Nicole Gaudette,  
Senior Planner  
City of Mercer Island Development Service Group

July 14,2018

**Subject: Response to comments**

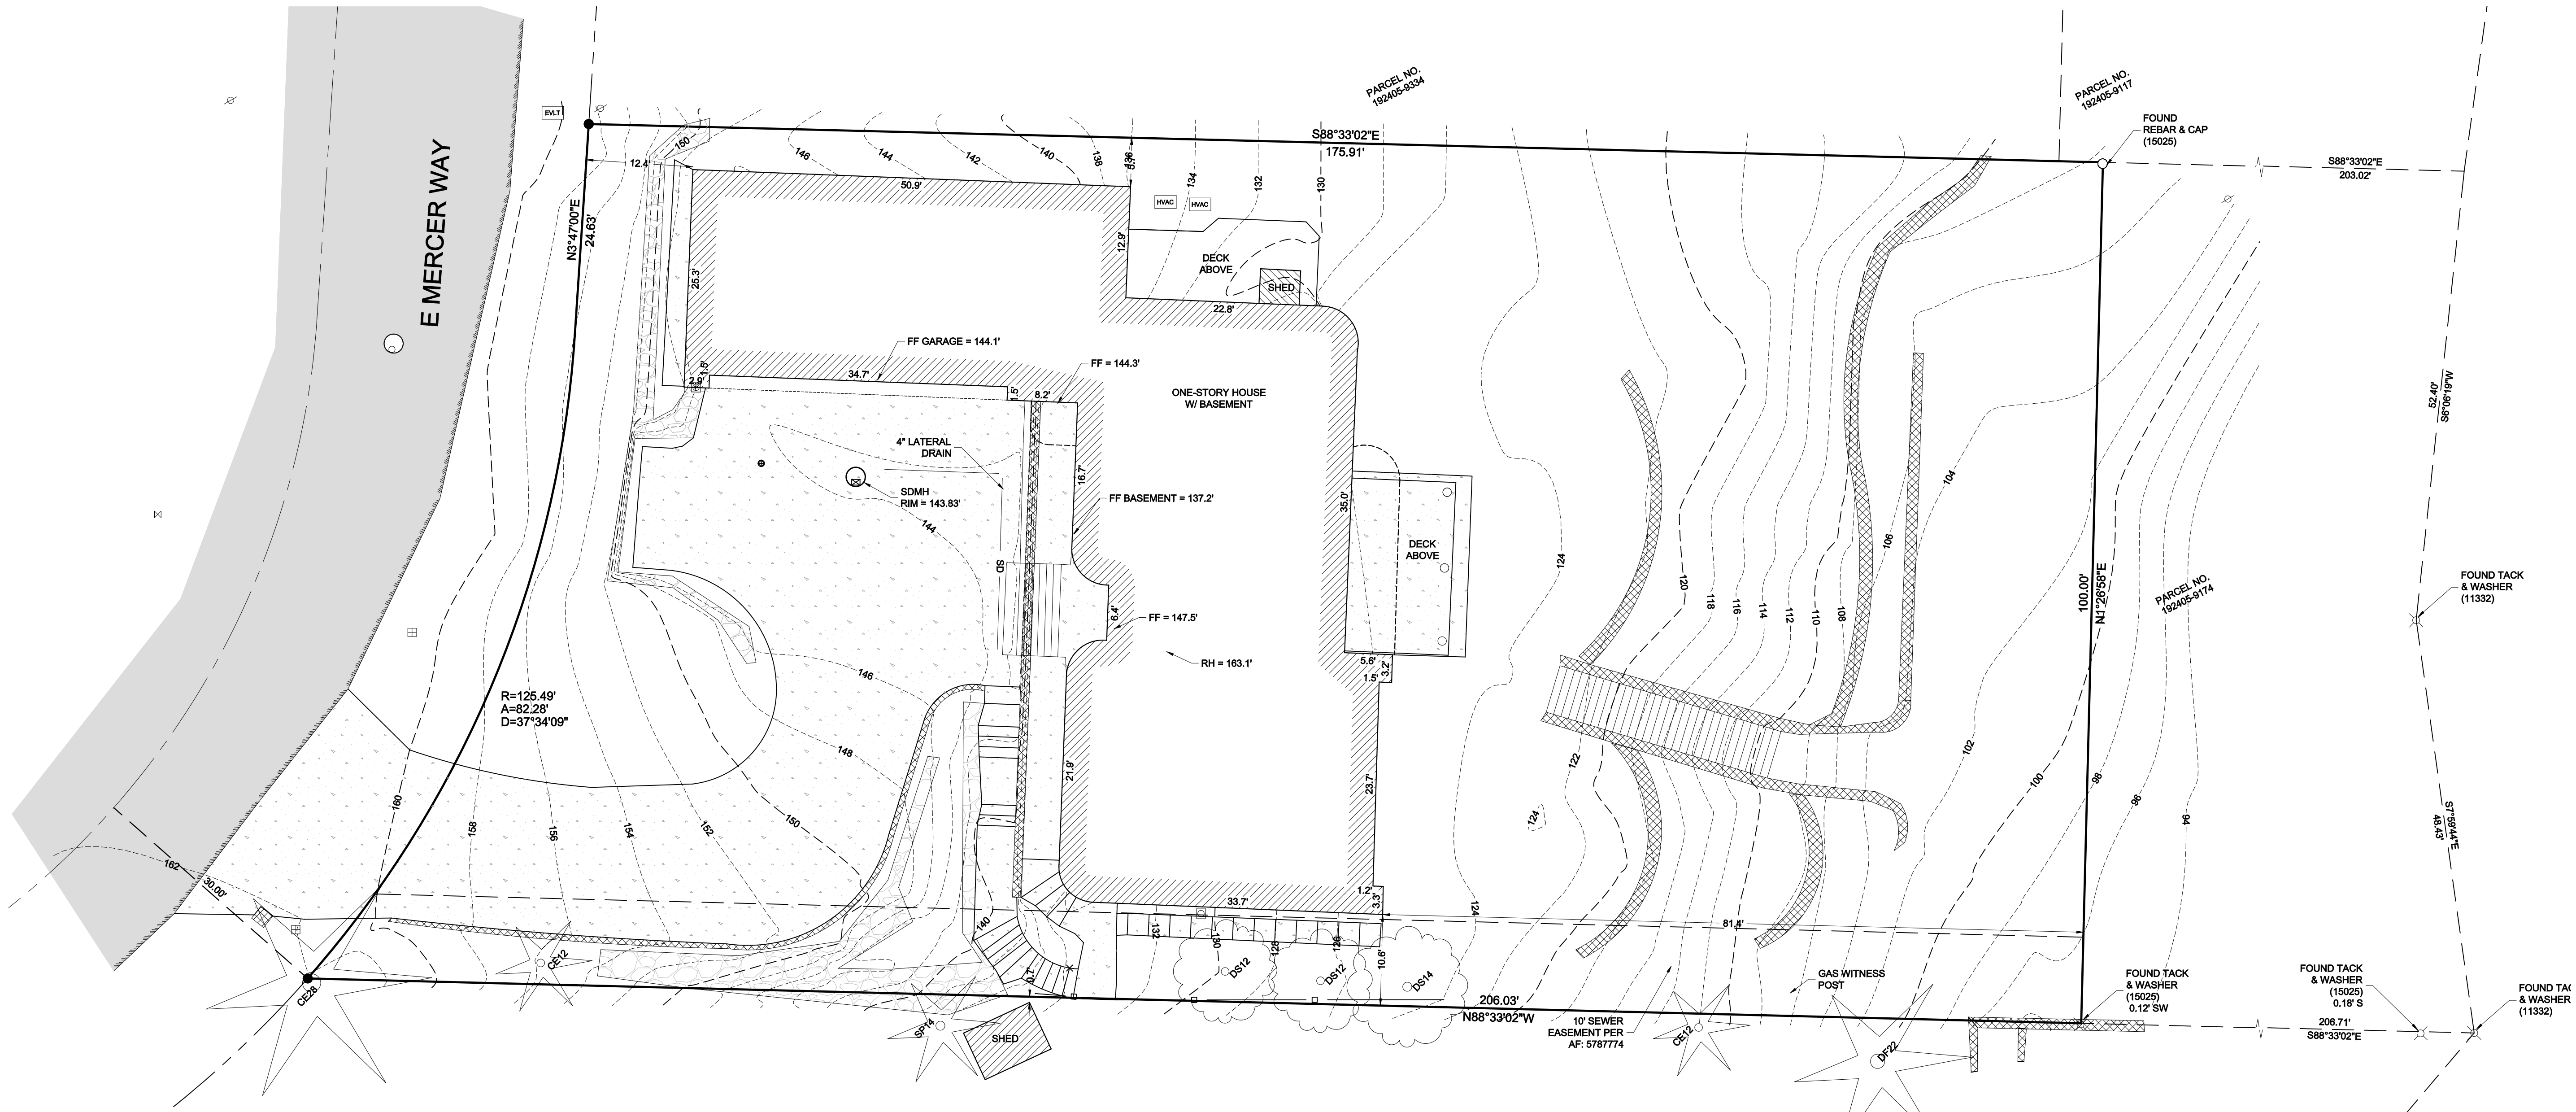
3. Please provide a numeric scale on the project plans (example: 1-inch equals 10-feet).

The site plan is in engineering scale. The plan sheet has engineering scale bar on it with 1"=20' if print out in paper size of 34"X22", if print out in paper size of 17"x11", 1"=40'.

Please see the updated plan sheet.
